M54- M6 Toll Link Road

Planning Inspectorate Reference: TR010054:

**Summary of Natural England's written representations**

3 November 2020

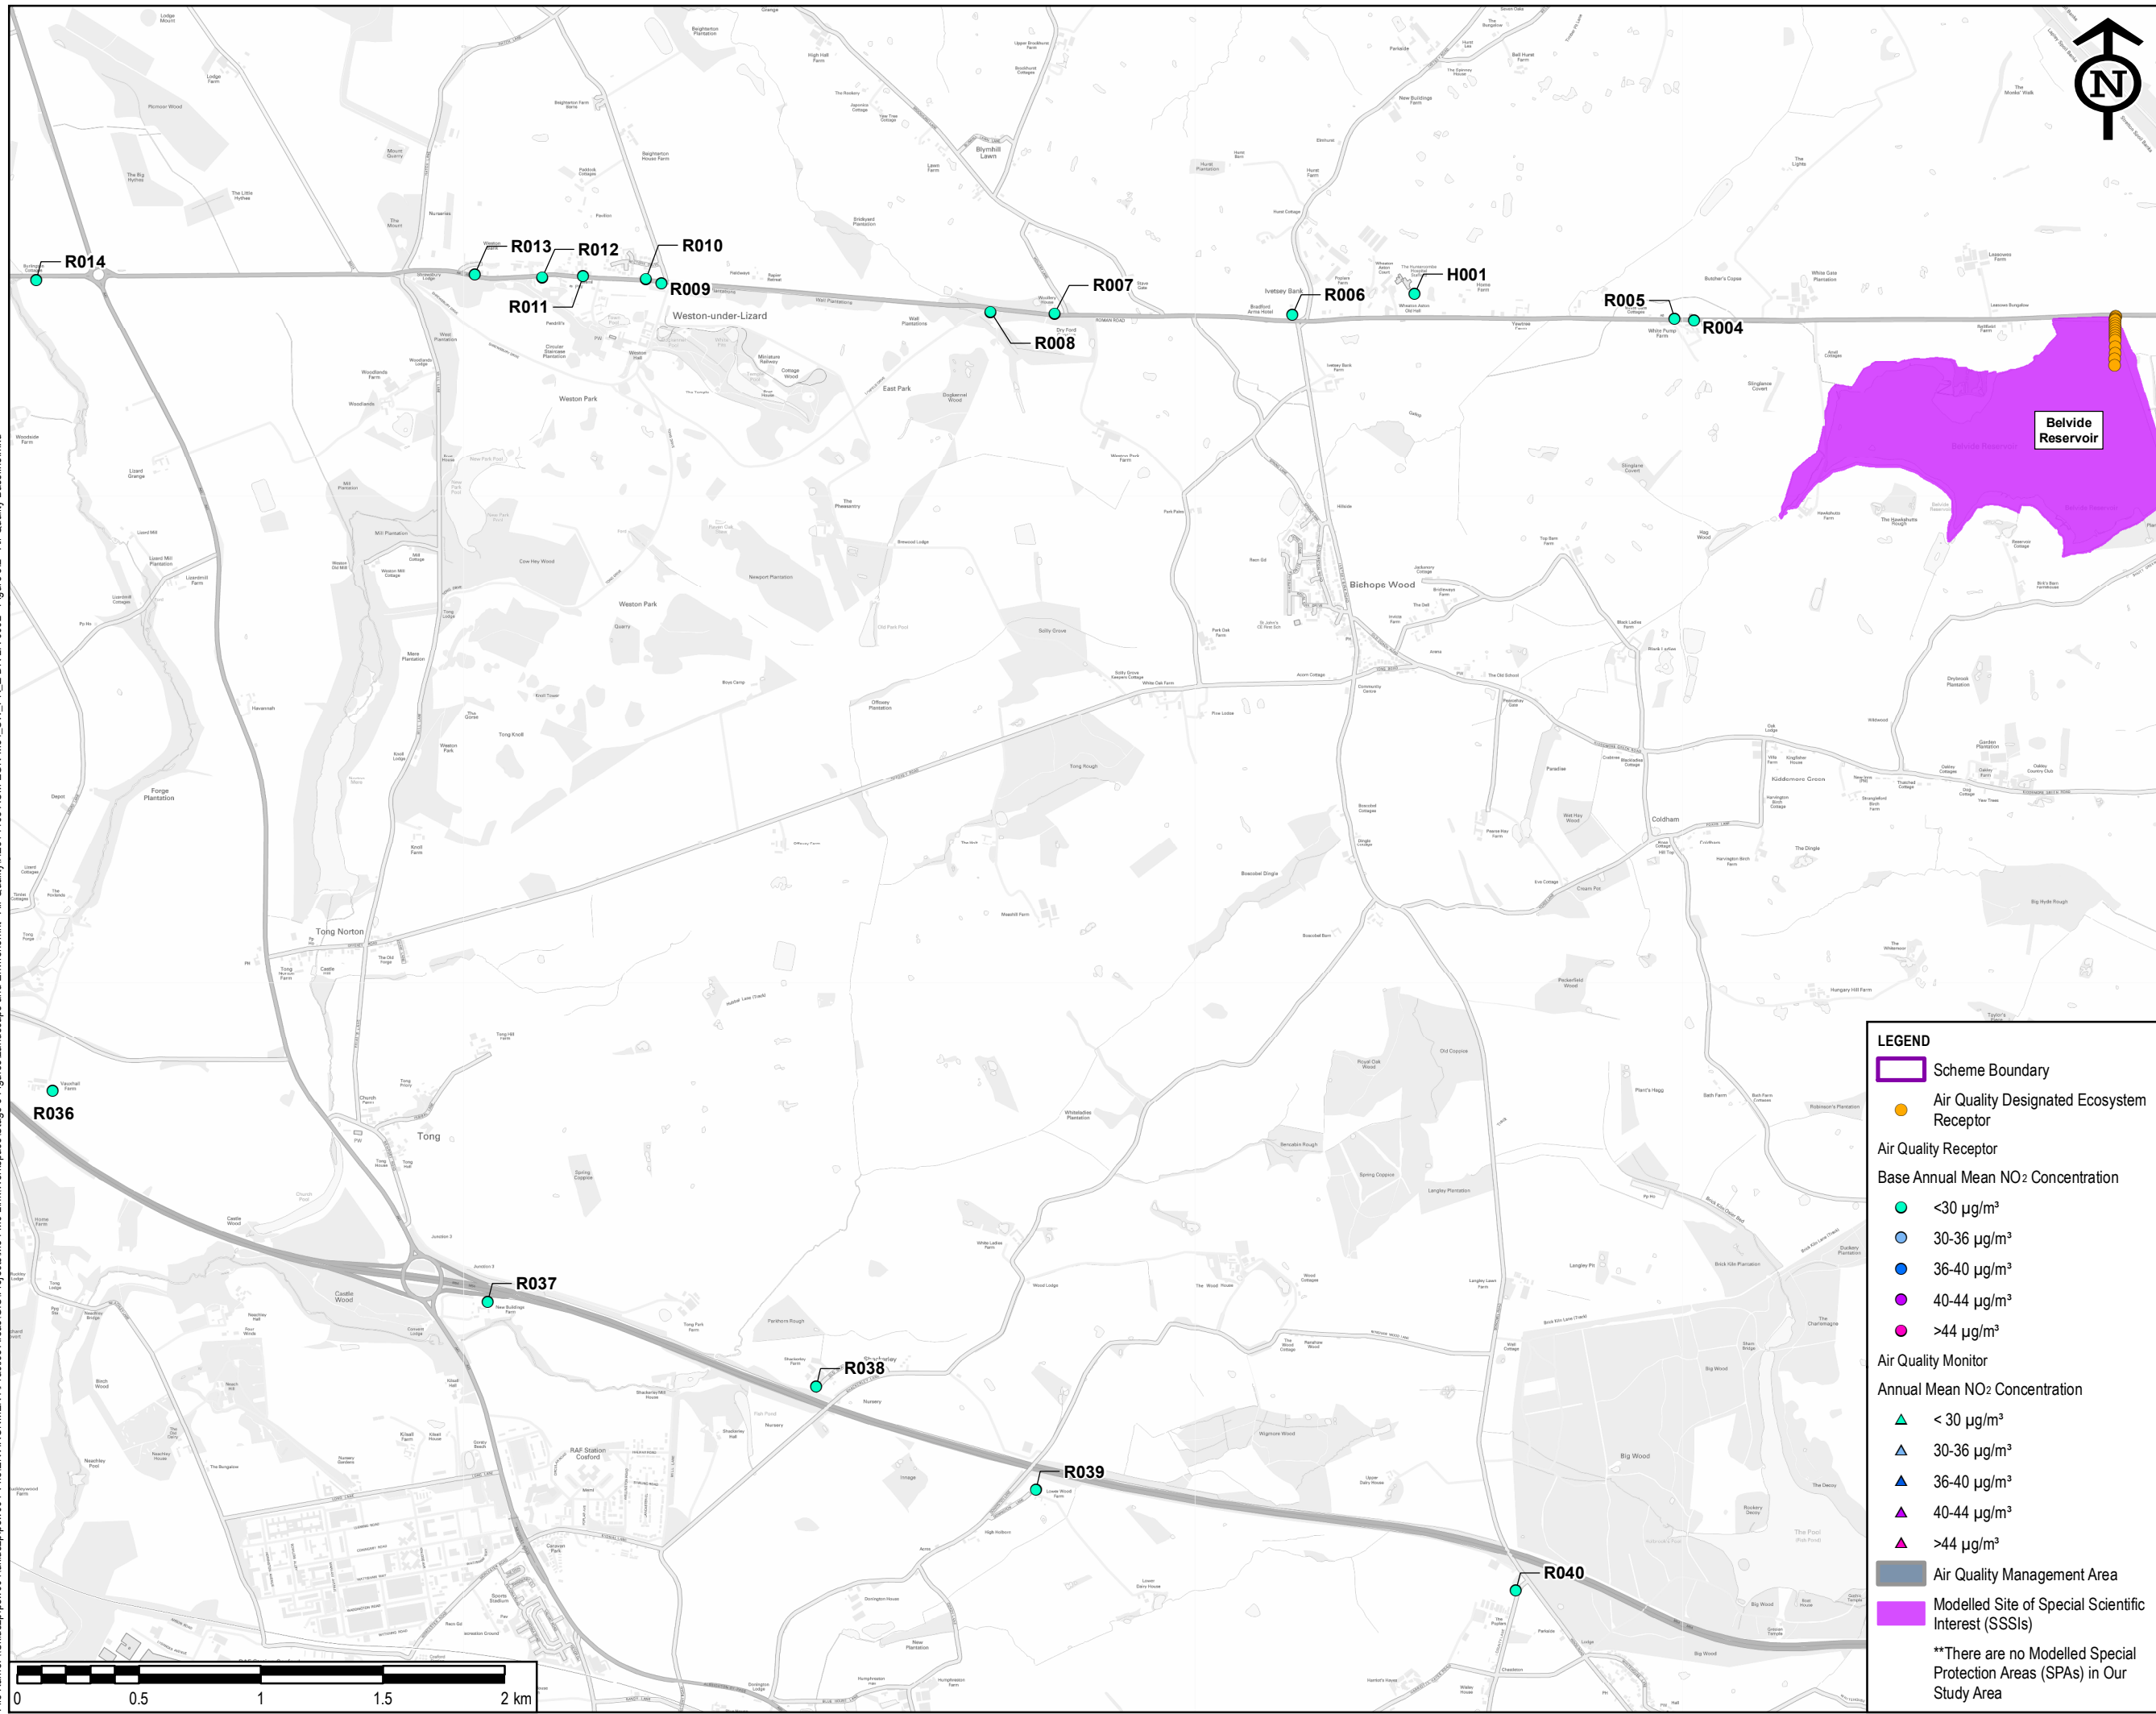
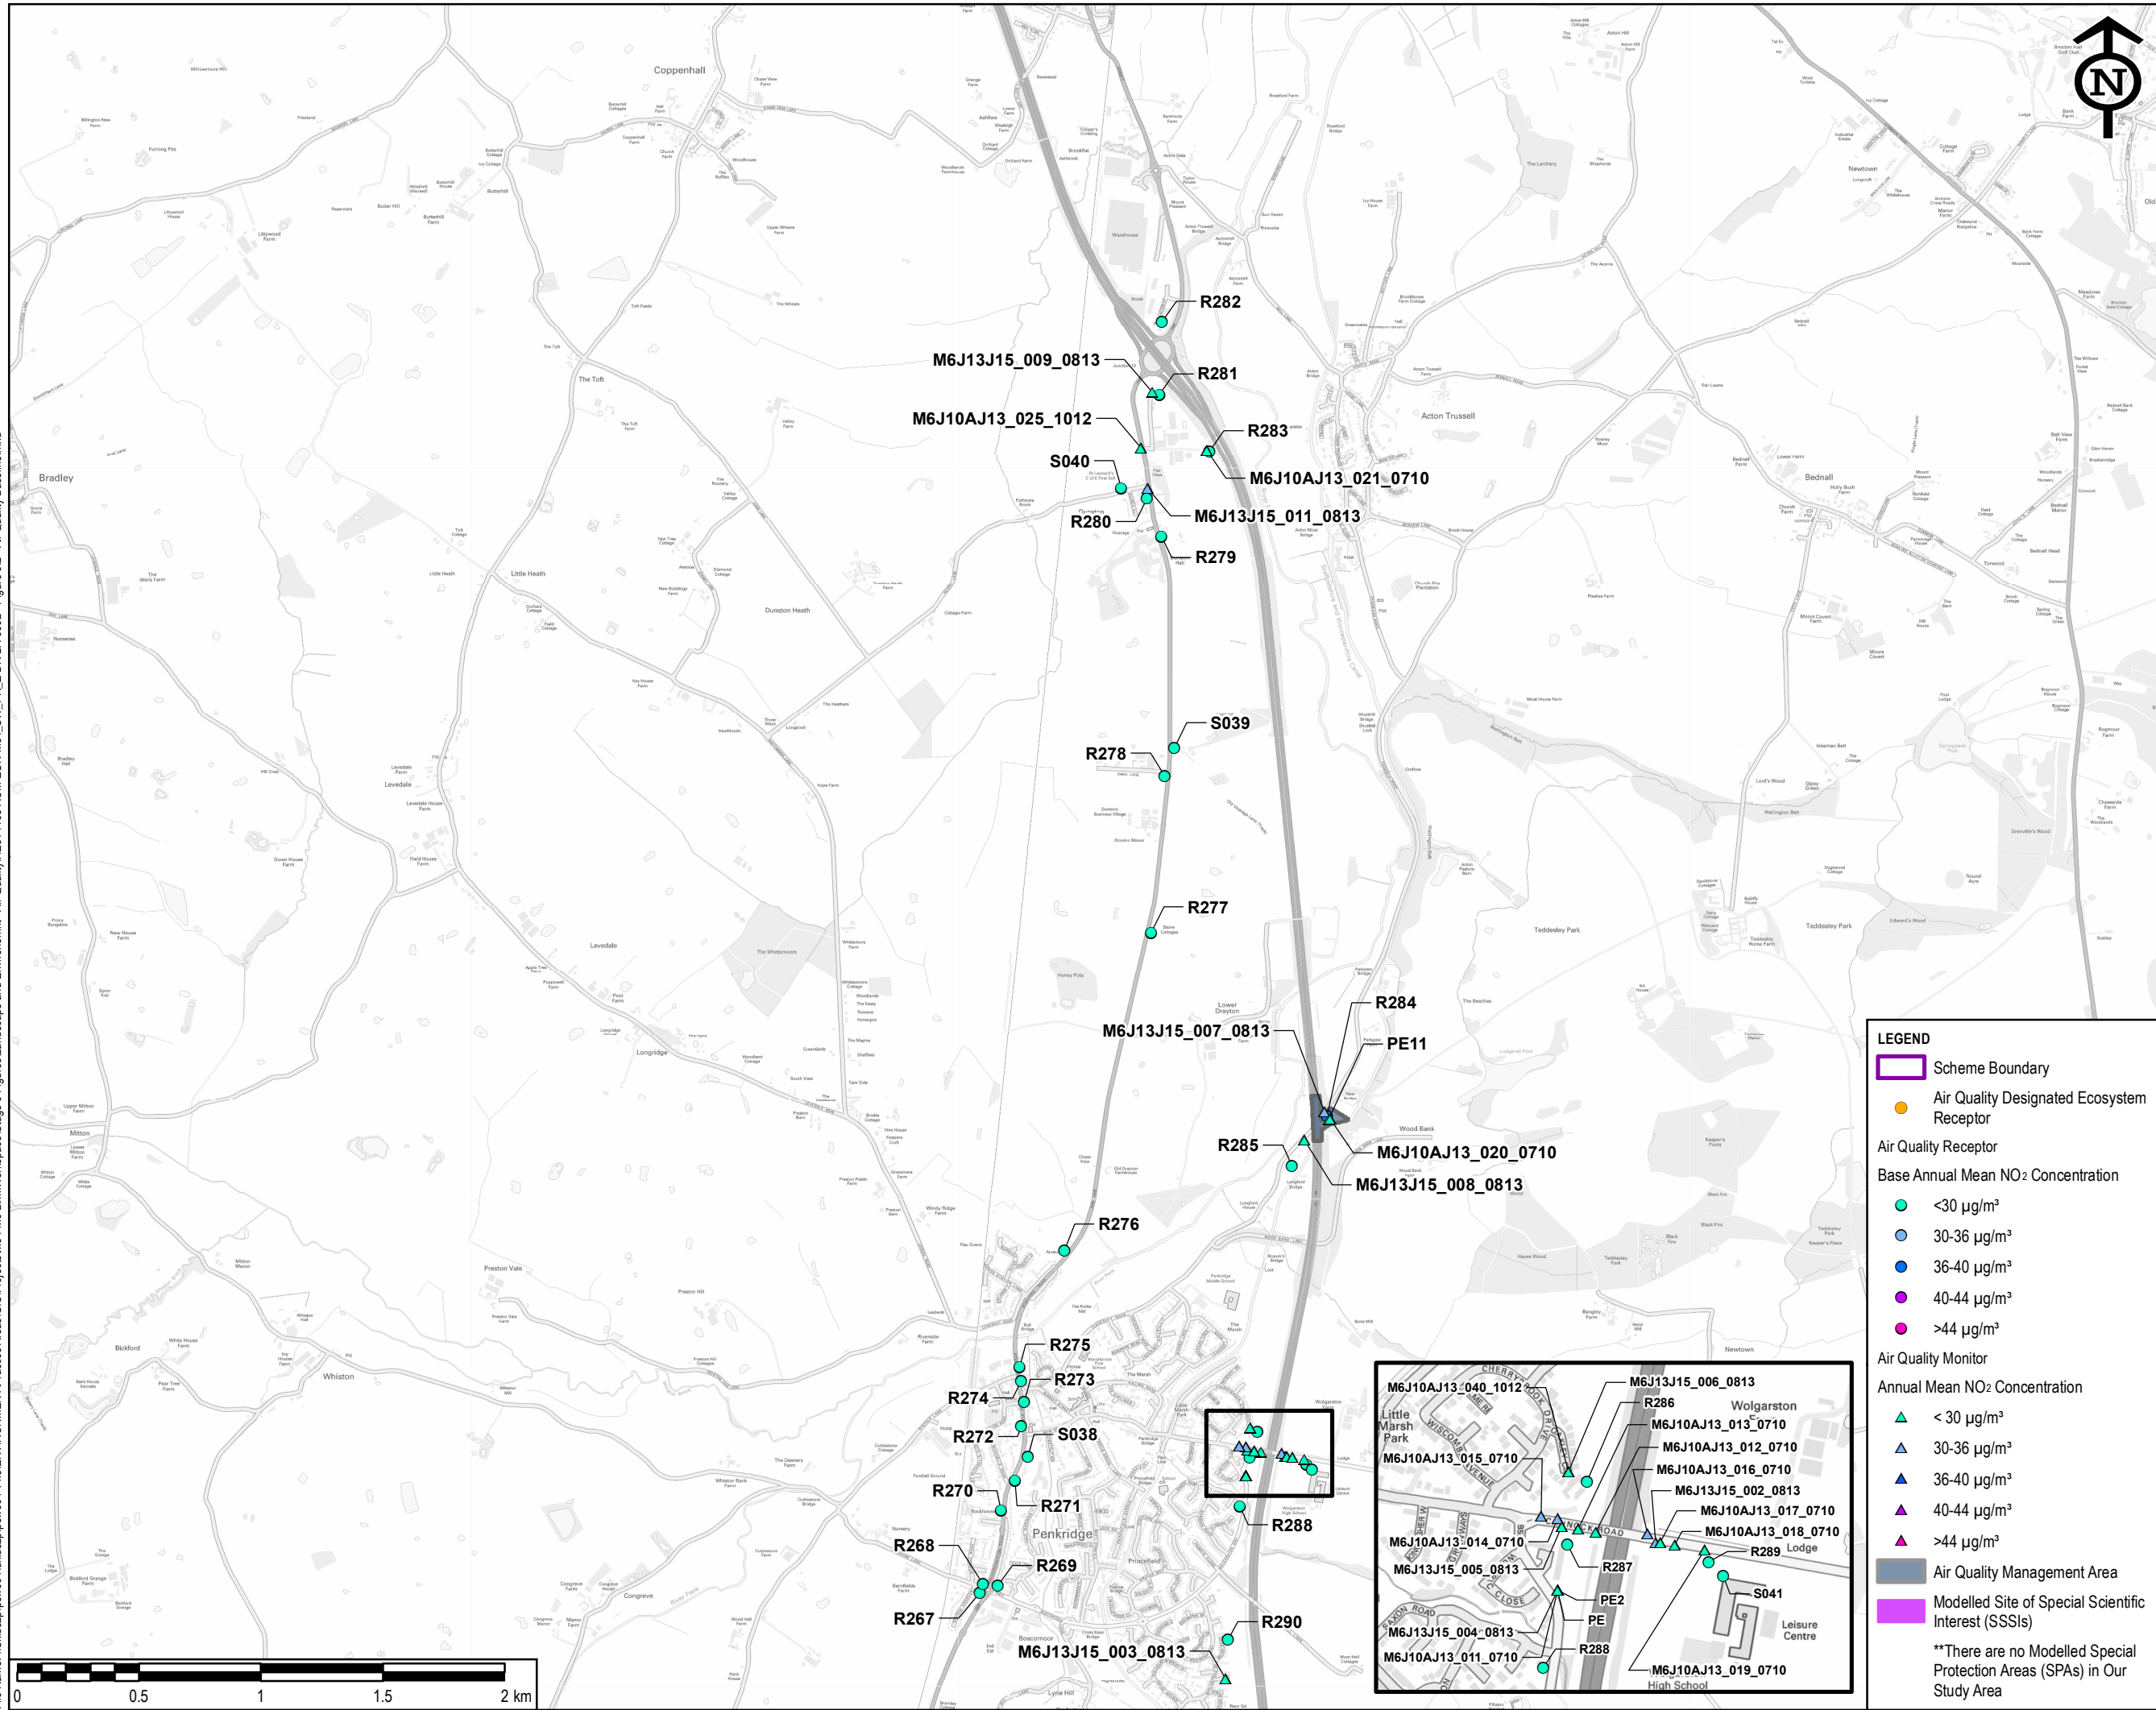
- Confirmation that example sites have been screened out.
      - Indirect impacts require consideration. Cannock Extension Canal SAC is hydrologically linked to Chasewater and Southern Staffordshire Coalfield Heath SSSI, which will be affected by nitrogen deposition.

- 3.2. Nationally designated sites
    - Chasewater and the southern Staffordshire Coalfield Heaths SSSI
    - Stowe Pool and Walkmill Claypit SSSI
      - The scheme would result in increases in NOx and nitrogen deposition at these sites further discussions are required over the assessment and conclusions with regards to potential impacts of these increases (alone and cumulatively) and mitigation.

- Where there is unavoidable loss of ancient woodland the Applicant and Natural England have agreed a ratio of replacement planting and improvement works to Oxden Leasow Wood (also known as Whitgreaves Wood). The detail of the compensation measures requires further discussion.
- Increases in nitrogen deposition on Oxden Leasow Wood and woodland at Brookfield Farm require further discussion on potential impacts on impacts alone and cumulatively.
